RE: 22/01682/F – Full Planning Application for the development of a ground mounted solar farm incorporating the installation of solar PV panels, associated infrastructure and access, as well as landscape planting and designated ecological enhancement areas. Land North of Manor Farm Noke.

Thank you for consulting us on this application. Following review of the supporting documentation, we have **NO OBJECTION** to the proposed development subject to the following conditions being applied to any planning permission for the Site.

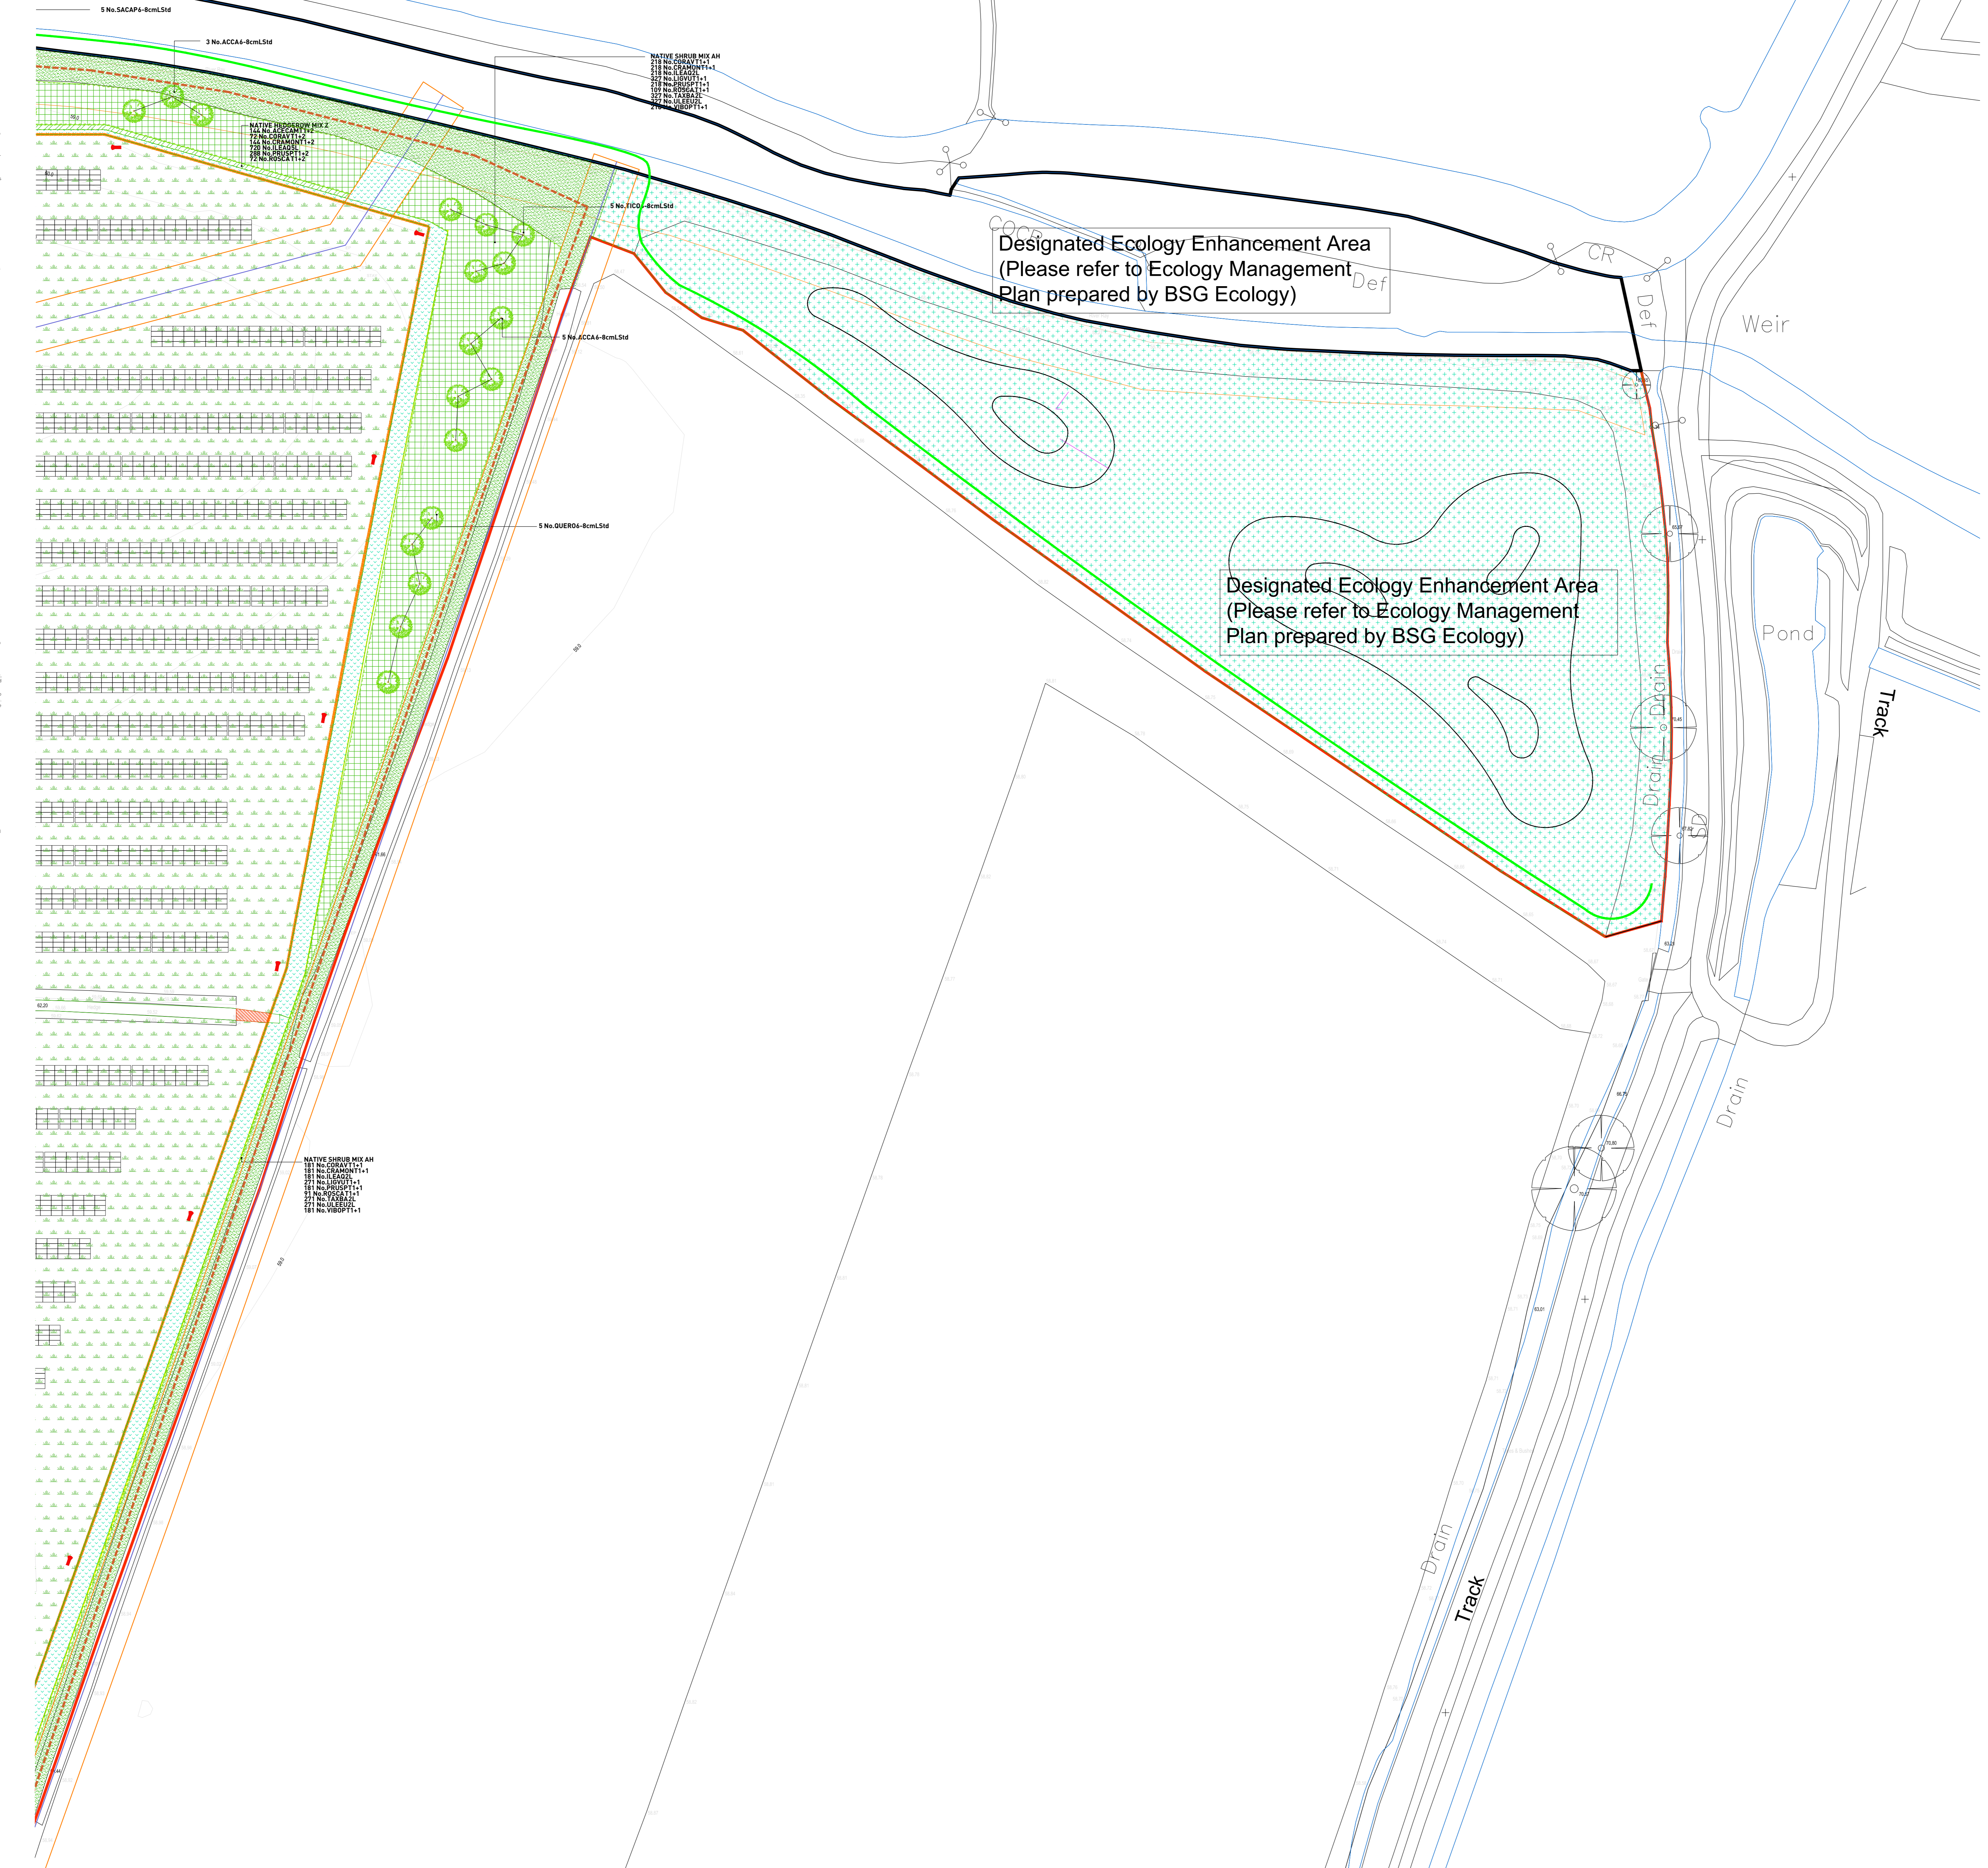
The route of the permissive path runs adjacent to the ecological enhancement area to the north and northeast. This location could contribute towards disturbance of any ground nesting birds. The design drawings and planting plan should therefore help to reduce this impact, through the planting of scrub and where needed fencing.

We appreciate the inclusion of the Turtle dove mix, as represented by a narrow linear strip on the design plan, however this form may make maintenance of the strip difficult to maintain. The foraging habitat should be provided in proximity to nesting habitats wherever possible and could be designed to cover the same area and be placed as several plots within the site.

The shrub mix shown in the design plans is excessively diverse. Areas planted in relation to turtle dove habitat will need to increase proportions of hawthorn, blackthorn and dog rose to generate suitable dense nesting habitat.

There doesn't appear to be any winter bird cover on the design plans. We would advise that some of the grassland creation is commuted to create this cover. Details on how to do this can be found here: <https://farmwildlife.info/how-to-do-it-5/seed-rich-habitats/wild-bird-seed-mix/>

We would expect selected tree or shrub species, planted on the Otmoor side of the development to be under 5 metres to ensure there is no adverse impact to wading bird species using the reserve.
